Application number: 2021/90800	
What is the application for?:	Redevelopment and change of use of former mill site to form 19 residential units
Address of the site or building:	Hinchliffe Mill, Water Street, Holmbridge, Holmfirth, HD9 2NX
Postcode:

User comments

HOUSE TYPE : UNIT 2

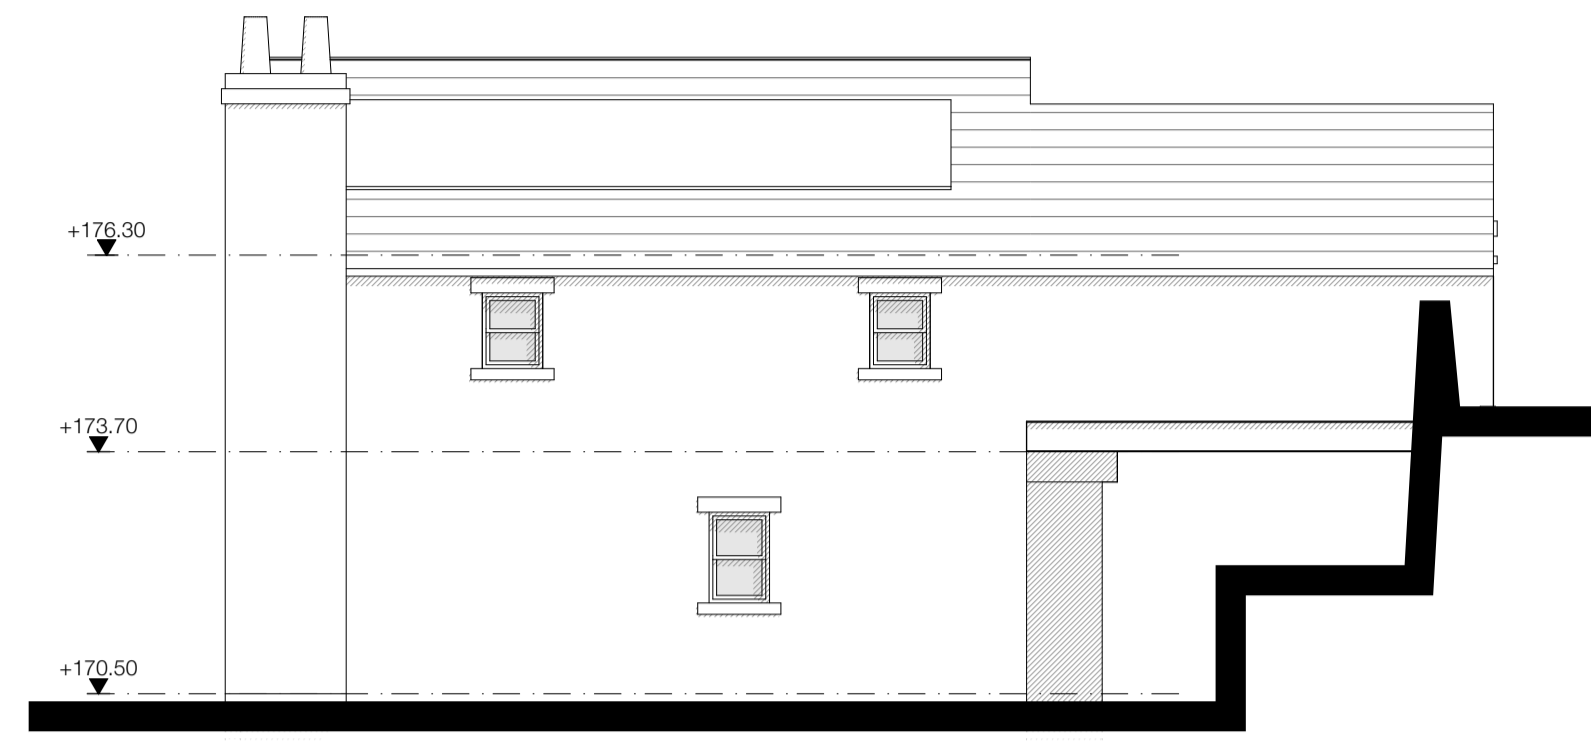
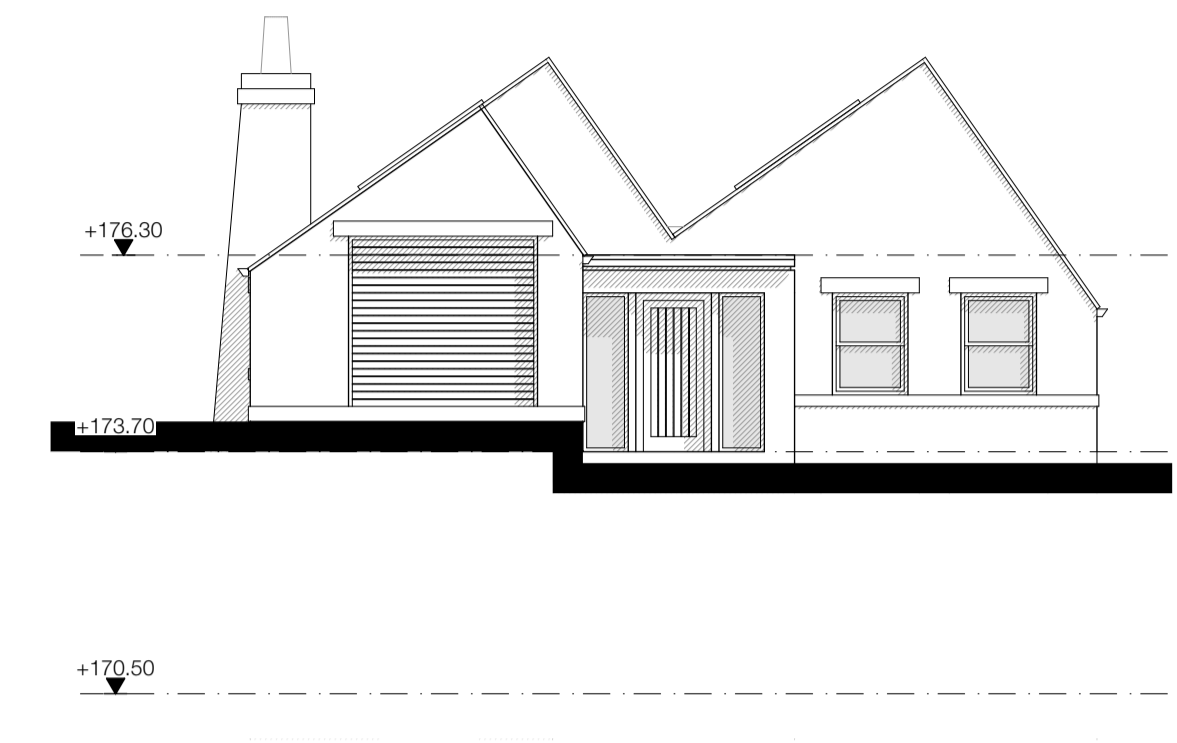
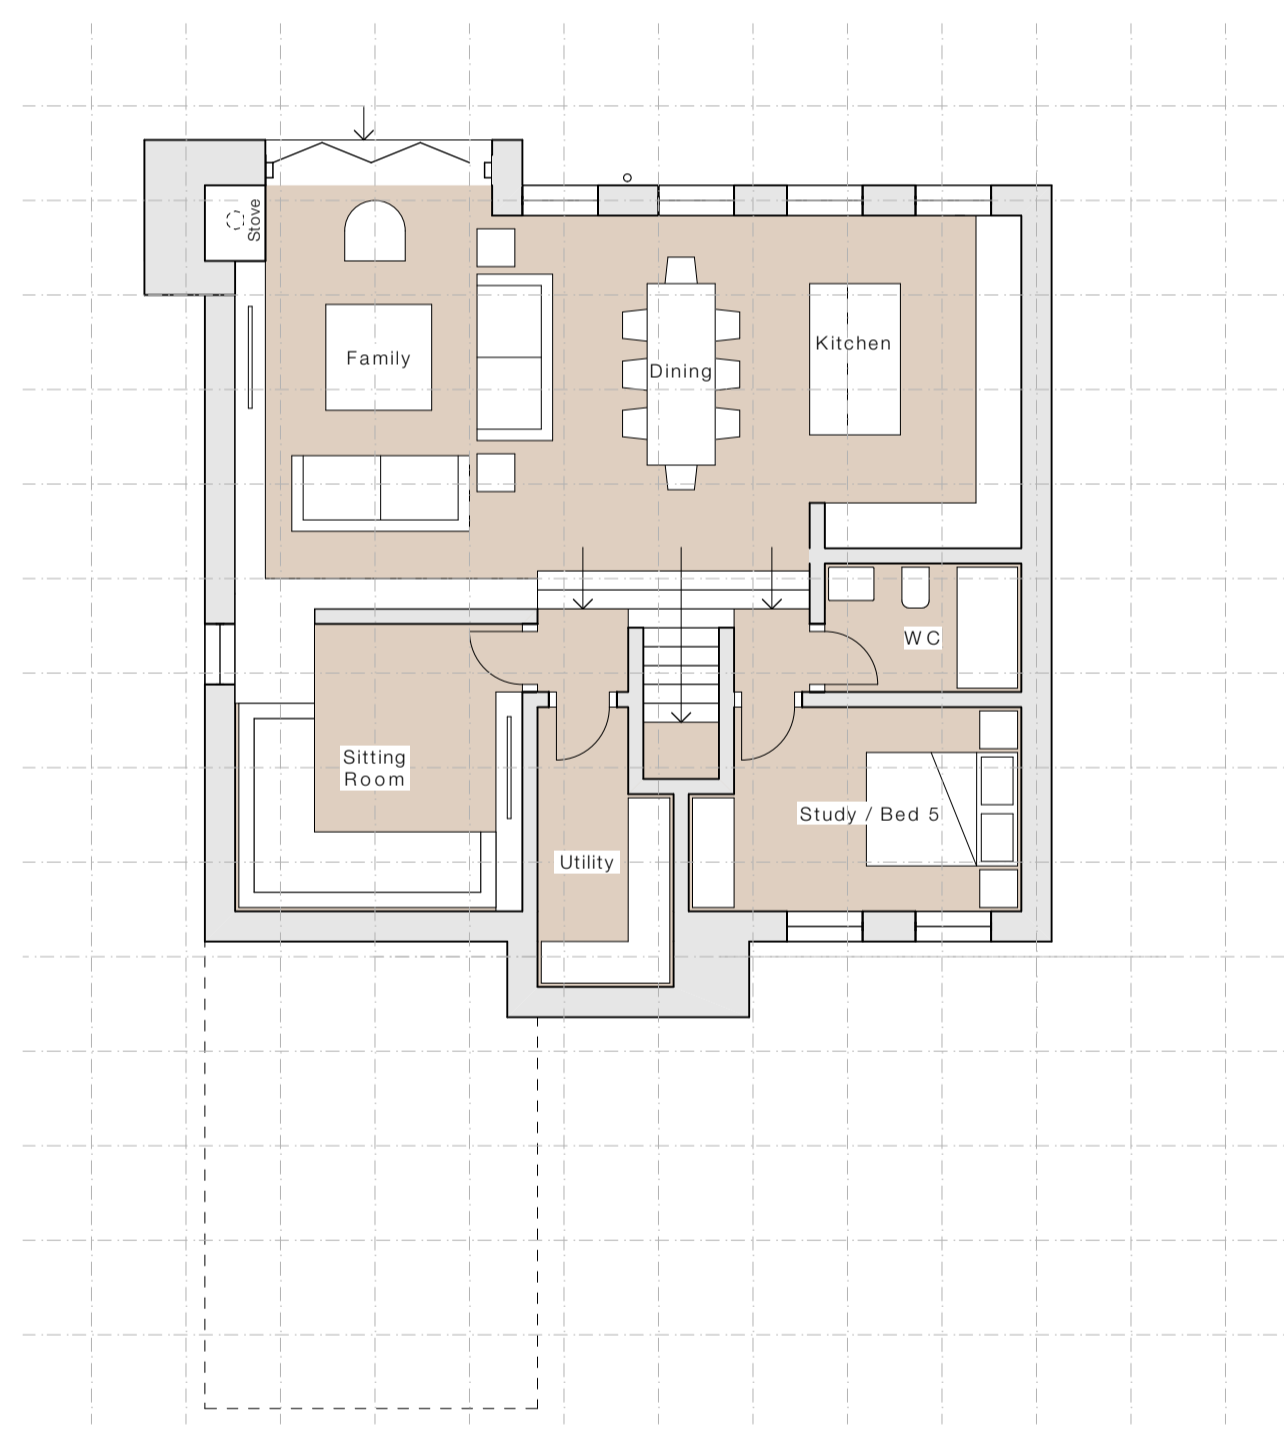
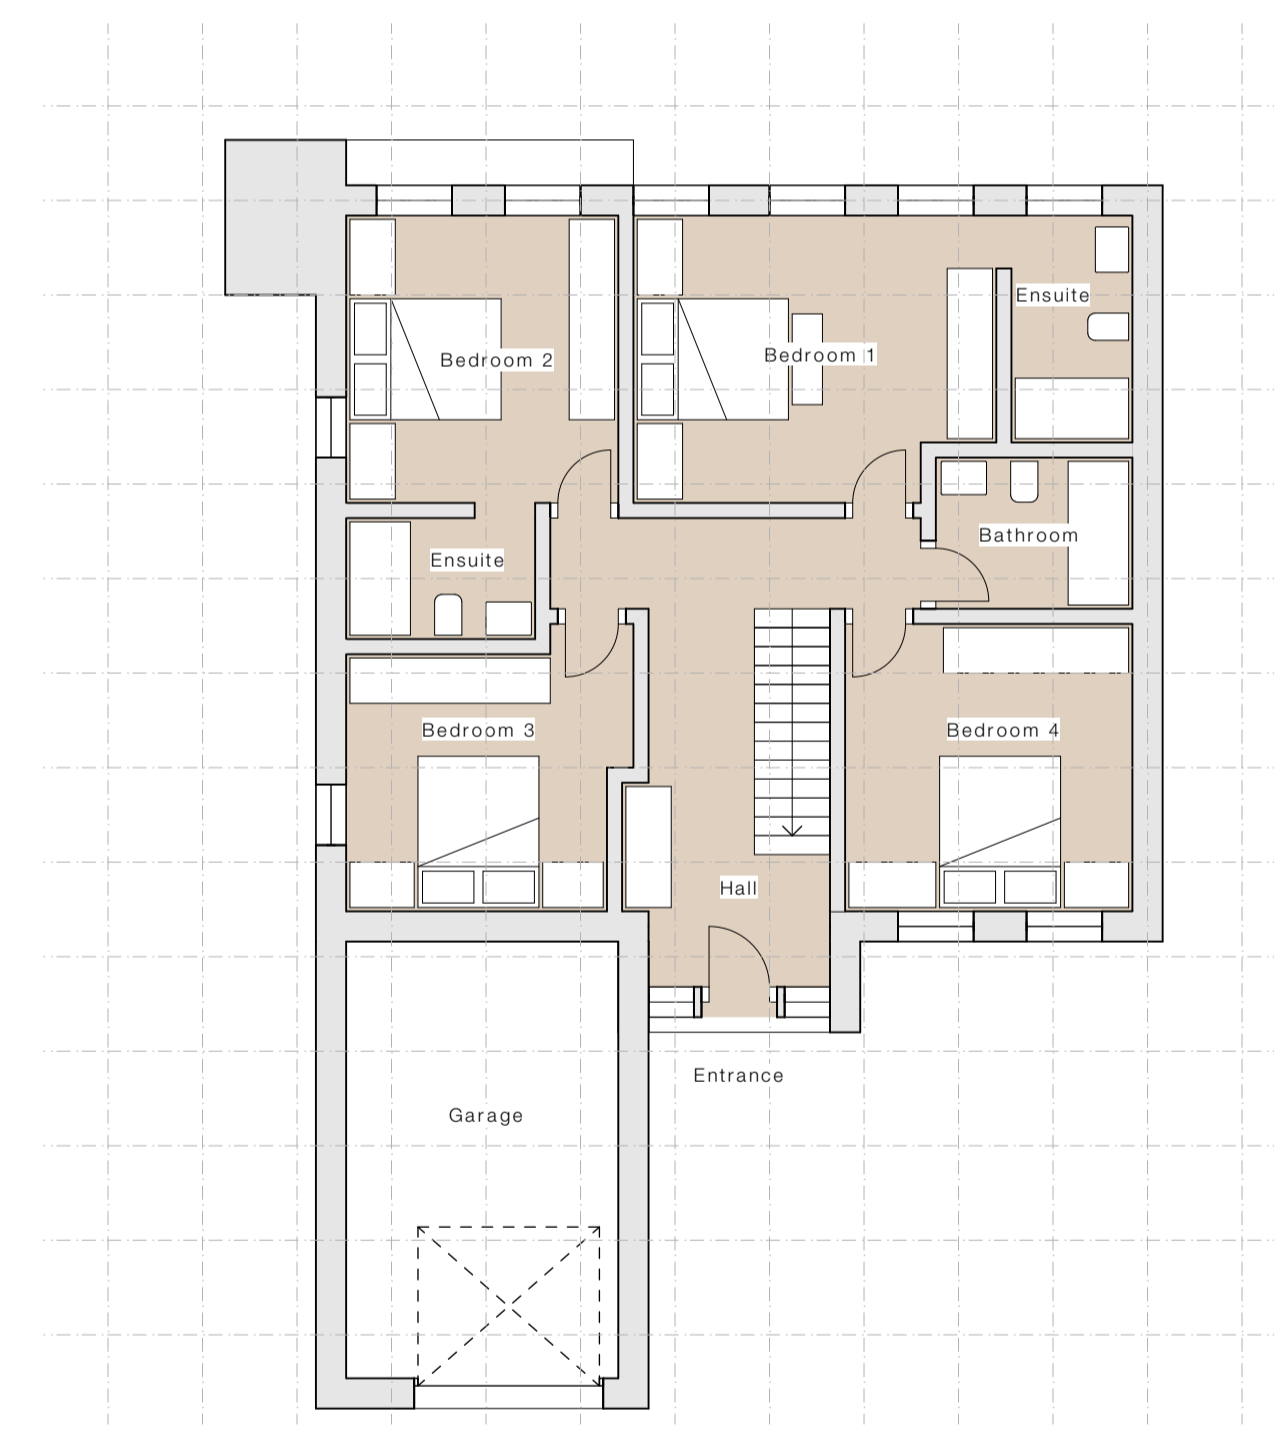
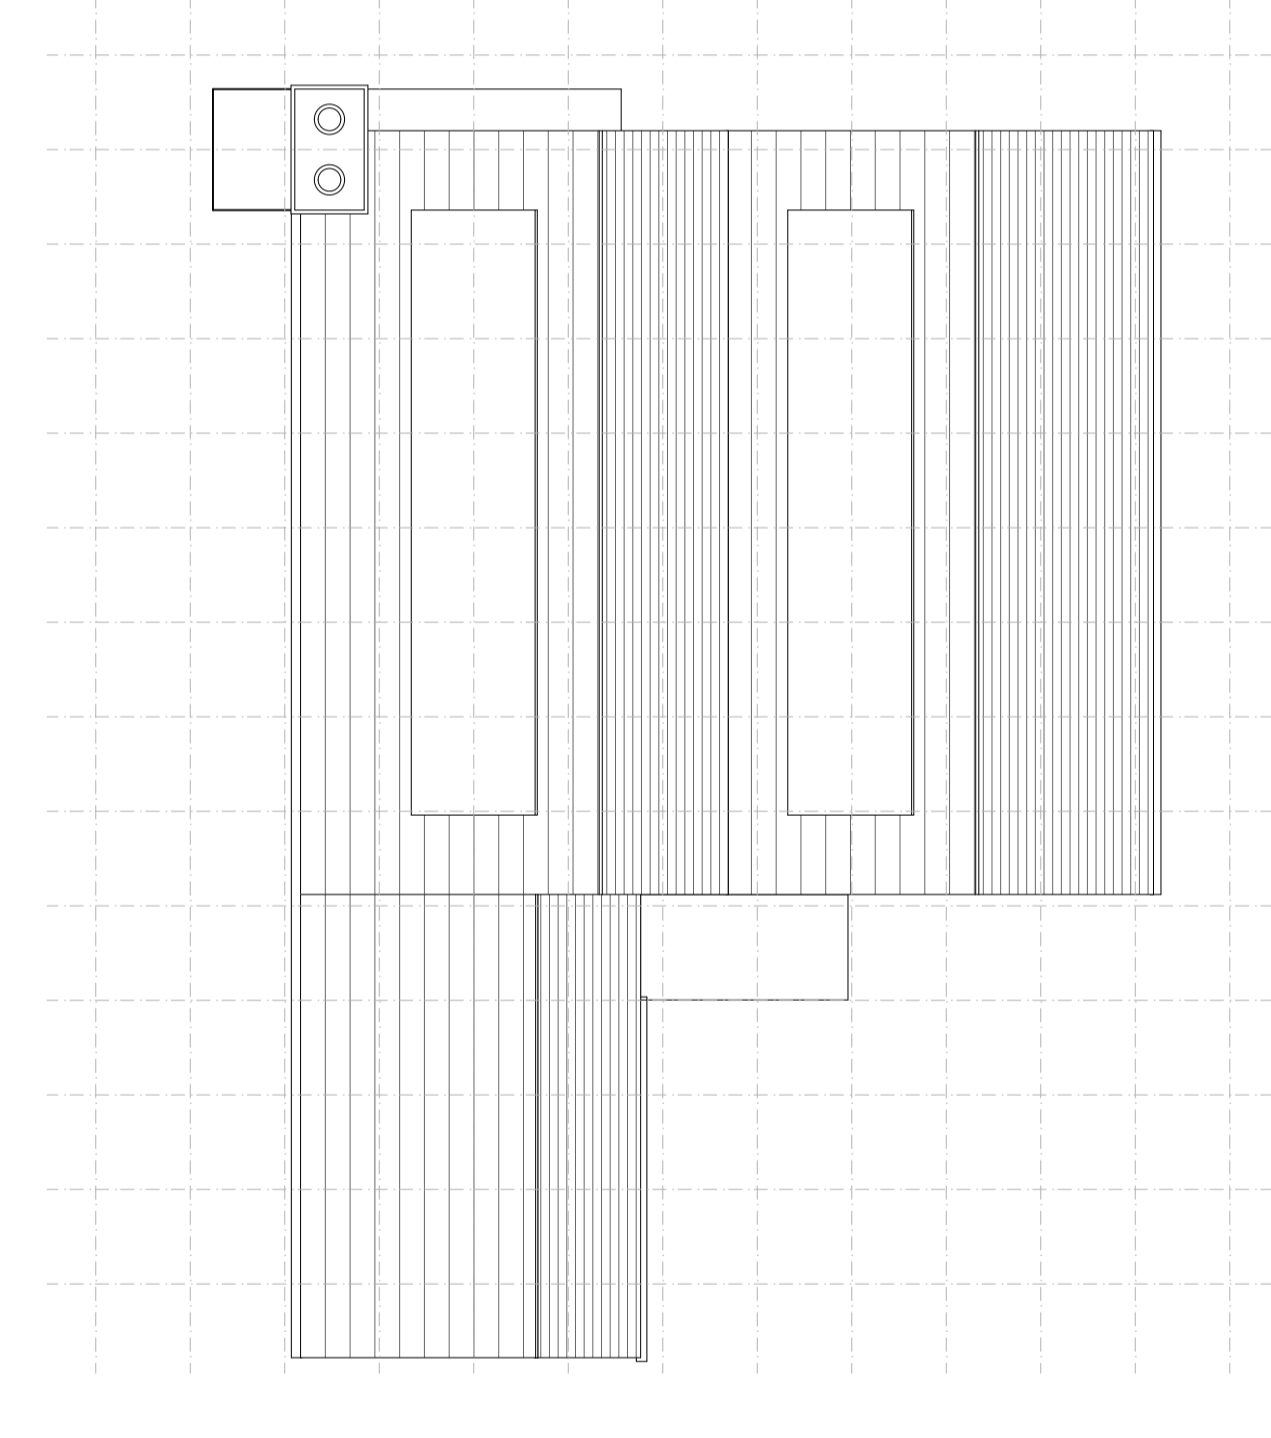
The scale and massing of plot 1 & 2 directly adjacent to the mill building, overlooking the dam are unduly dominant and out of scale with the heritage Class 3 asset mill building which would lose its local prominence, adversely affecting its village-scape merit and immediate setting. Historic England submitted concerns that previous plans presented a 'domestic' feel, at odds with the industrial character of the site which would not preserve or enhance the special interest of surrounding designated and non-designated assets and would be harmful to the character and appearance of the conservation area, and consequently cannot be supported. Complete removal of plot 1, or further reduction in scale and massing of plot 1 & 2 is required. Further design consideration is needed in keeping with the context of the industrial setting and surrounding properties in this conservation area.
